Re: Response to Review Comments  
Retreat at Prairie Ridge Preliminary Plan Phase 1  
El Paso, Colorado  
Entech Job No. 212381

Colorado Geological Survey, date May 6, 2024. *Review Comments by the Colorado Geological Survey, Retreat at Prairie Ridge Preliminary Plan Phase 1 (AKA Jaynes).* CGS Unique No. EP-24-0047\_2.

CGS Unique No.: EP-24-0047\_2 Retreat at Prairie Ridge Preliminary Plan Phase 1 (AKA Jaynes)

**PROPOSED CUT/FILL NORTHERN  
RETREAT AT PRAIRIERIDGE**  
 POCO ROAD & VOLLMER ROAD  
 EL PASO COUNTY, CO  
 ELITE PROPERTIES OF AMERICA, INC.

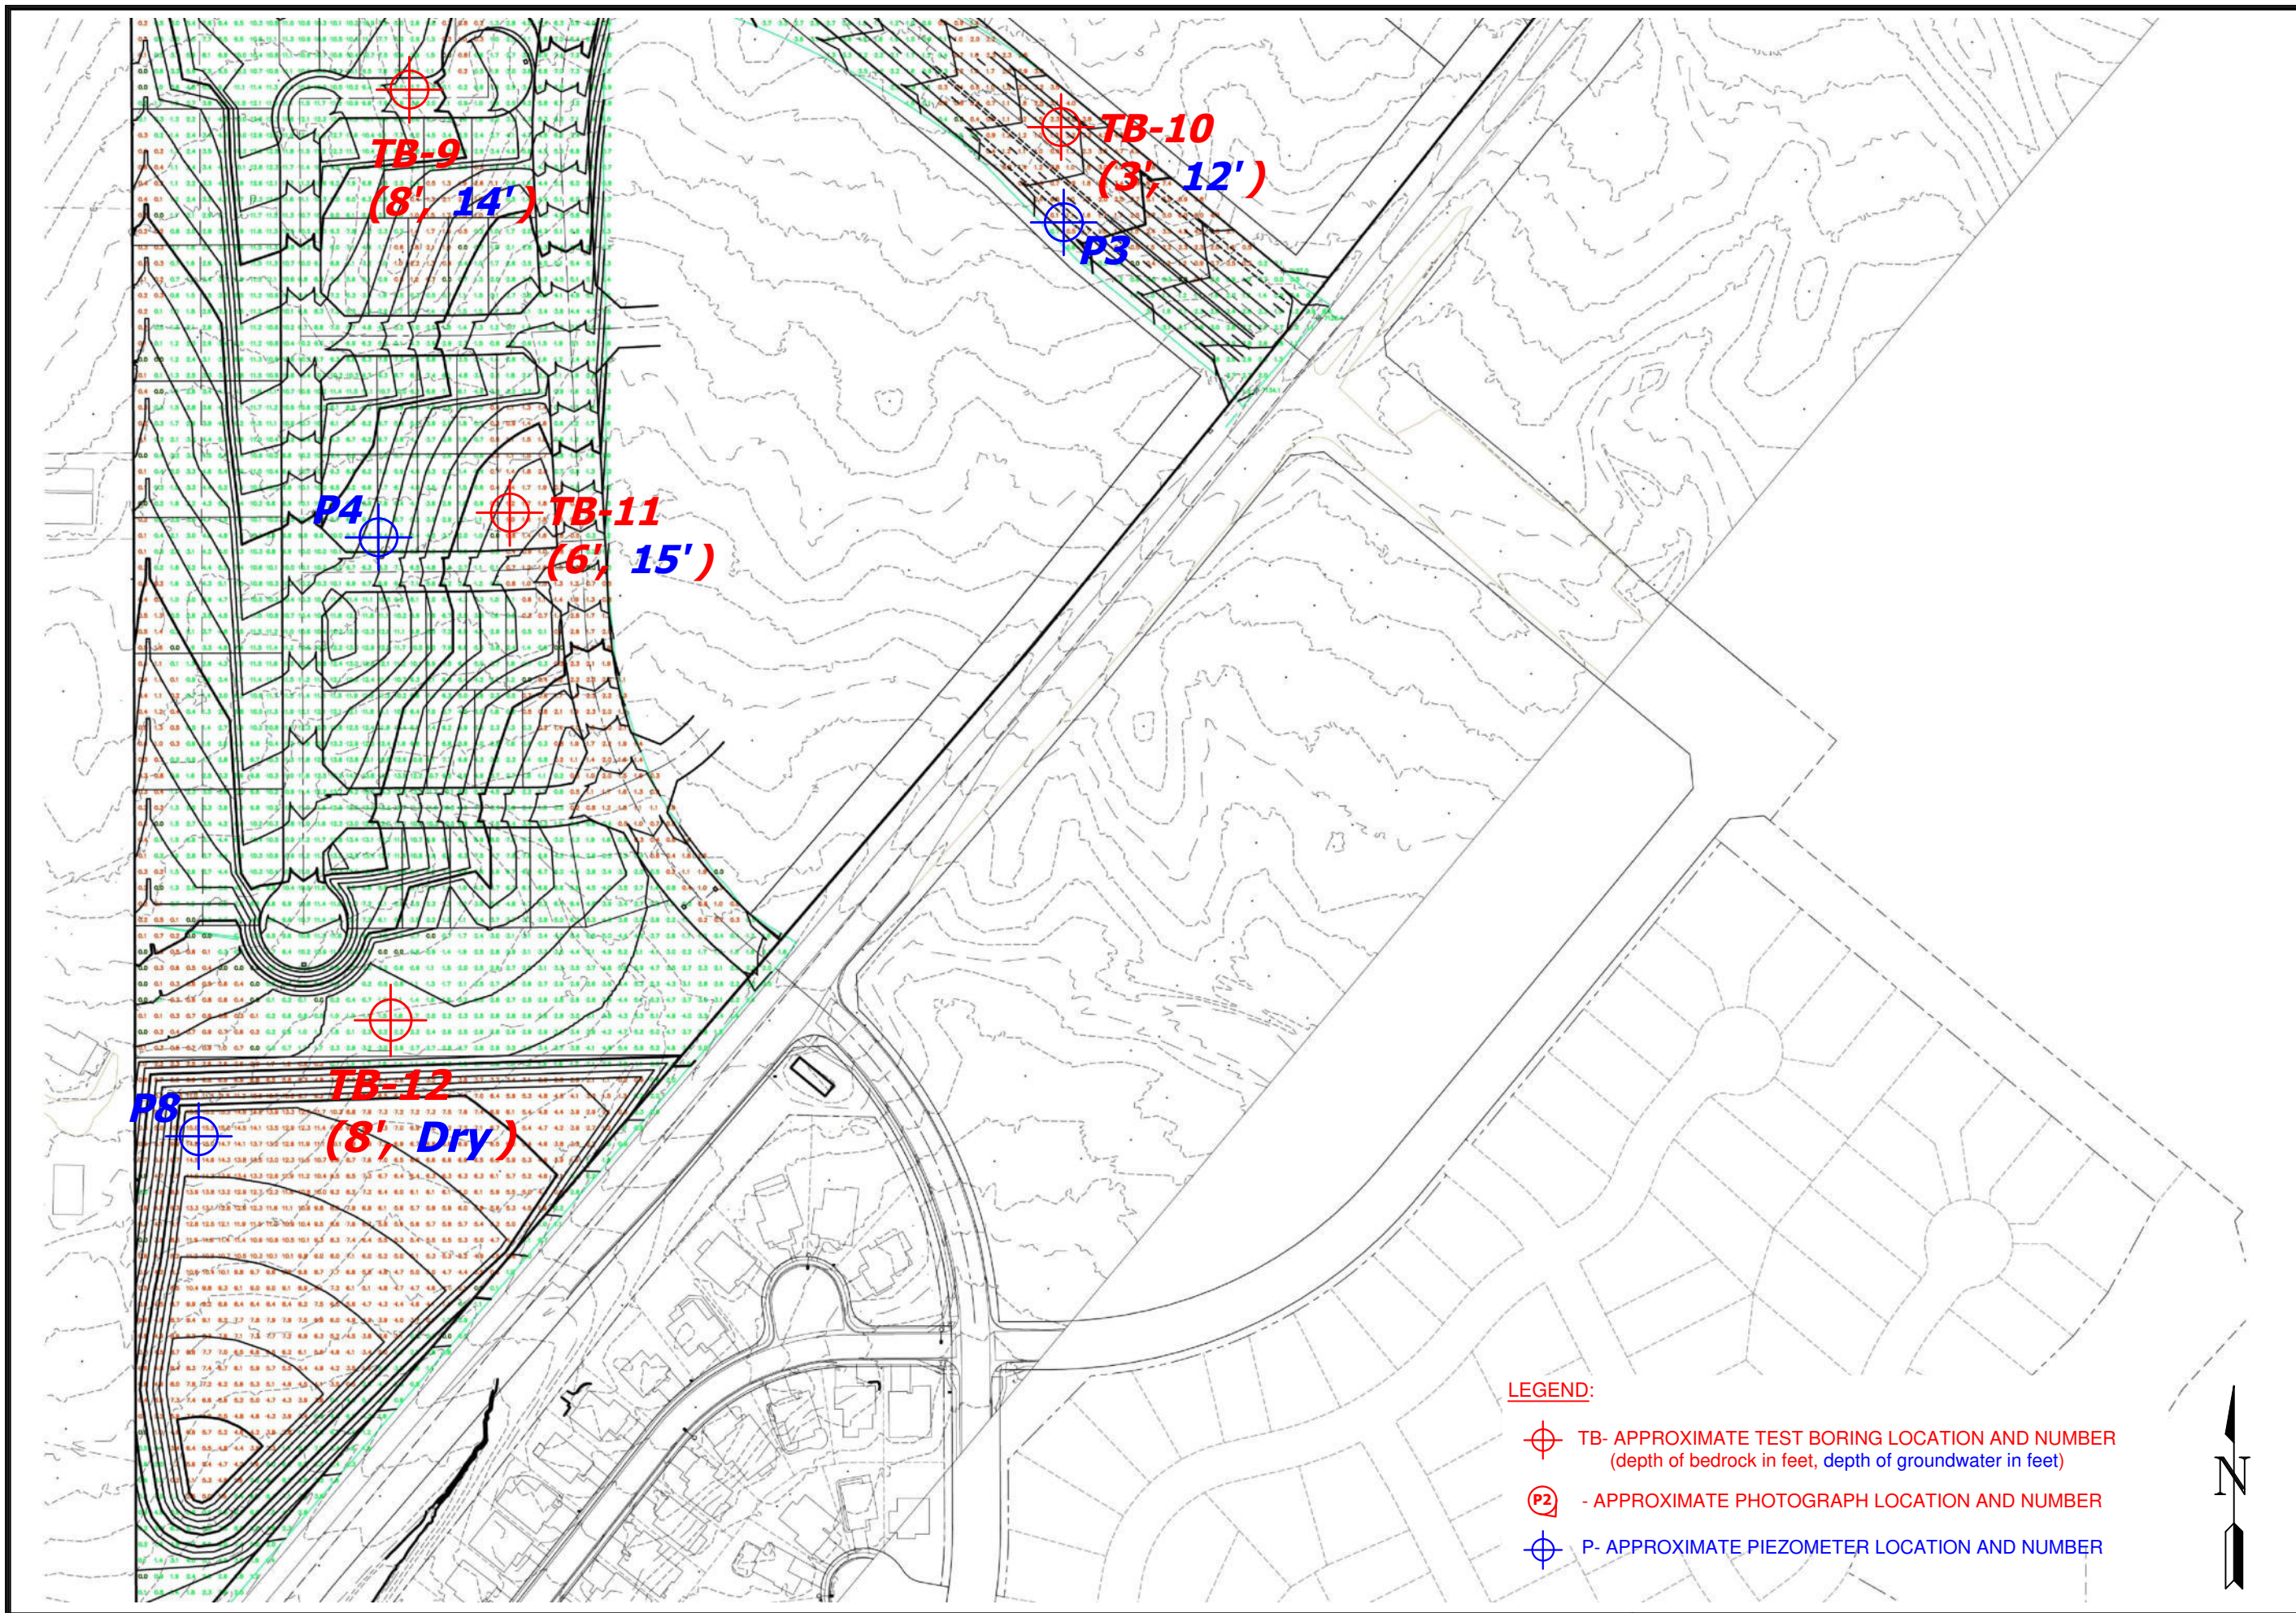
1. Entech states (page 13), “Cuts of up to 30 feet are anticipated in the north central portion of the site.” Groundwater was encountered at 6 to 28 feet below grade during drilling, and Entech observed areas of ponded water in some locations. Also, bedrock was encountered in the test borings at depths of 1 to 9 feet. These conditions will significantly affect the excavation/grading operations at this site. The shallow groundwater conditions likely preclude the construction of below-grade levels for this development.

**Entech Response to Comment 1:** Deep cuts are proposed at the ridge in the center of the site. The cuts will encounter bedrock which will require excavators and/or rock buckets. Water was encountered at 29 feet near the ridge. While water is present at or near cut depths, the sandstone will be stable where water is encountered. The overlot grading on the site will alter the groundwater across the site. It is also anticipated that water will be lowered with the utility installation. At this time, it is our opinion that evaluation of areas suitable for basements/no basements should be made after grading and additional investigation. Piezometers will be monitored during the development process.

**GEOLOGY/ENGINEERING MAP**  
 RETREAT AT PRAIRIERIDGE  
 POCO ROAD & VOLLMER ROAD  
 EL PASO COUNTY, CO  
 ELITE PROPERTIES OF AMERICA, INC.

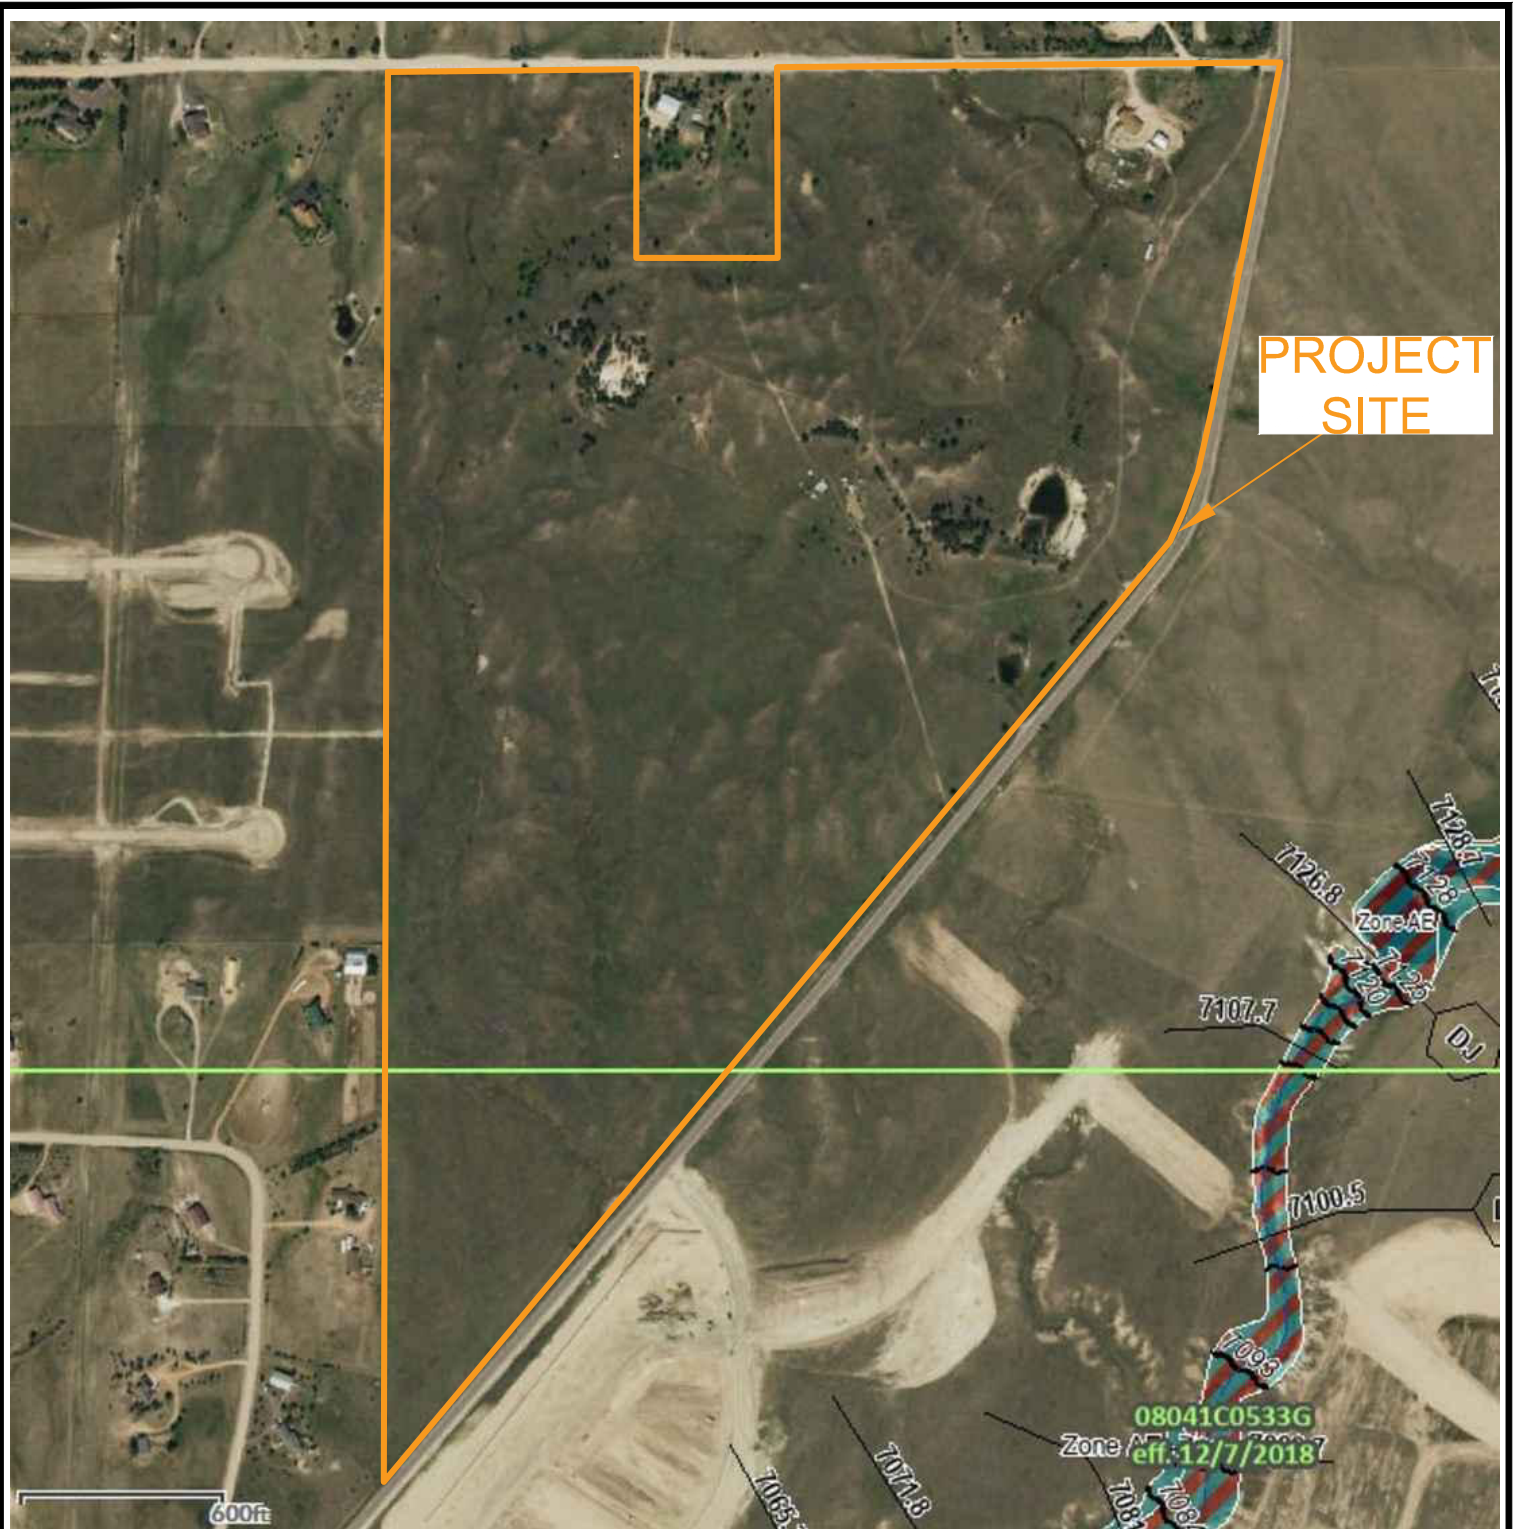
2. Test Boring 4, P2, P3, and P4 show groundwater at depths of 6.5 to 11.5 feet below grade. These areas are depicted as TKd (Dawson Formation) in Figure 8 of Entech’s report and Sheet 28 of the preliminary plan. These areas also contain potentially seasonally shallow groundwater (psw) or seasonally wet area (sw) and should be updated.

**Entech Response to Comment 2:** Test Boring 4 (TB-4) is located in the large lot (5-acre) area. Additional investigation on each of the large, rural lots will be required prior to construction. Piezometers P2 and P4 are located in areas to be filled. After grading, the water depths are expected to be 23 and 17 feet. These areas should be suitable for basement construction. Piezometer 3 (P3) is located along the roadway alignment and not in an area of residential lots.
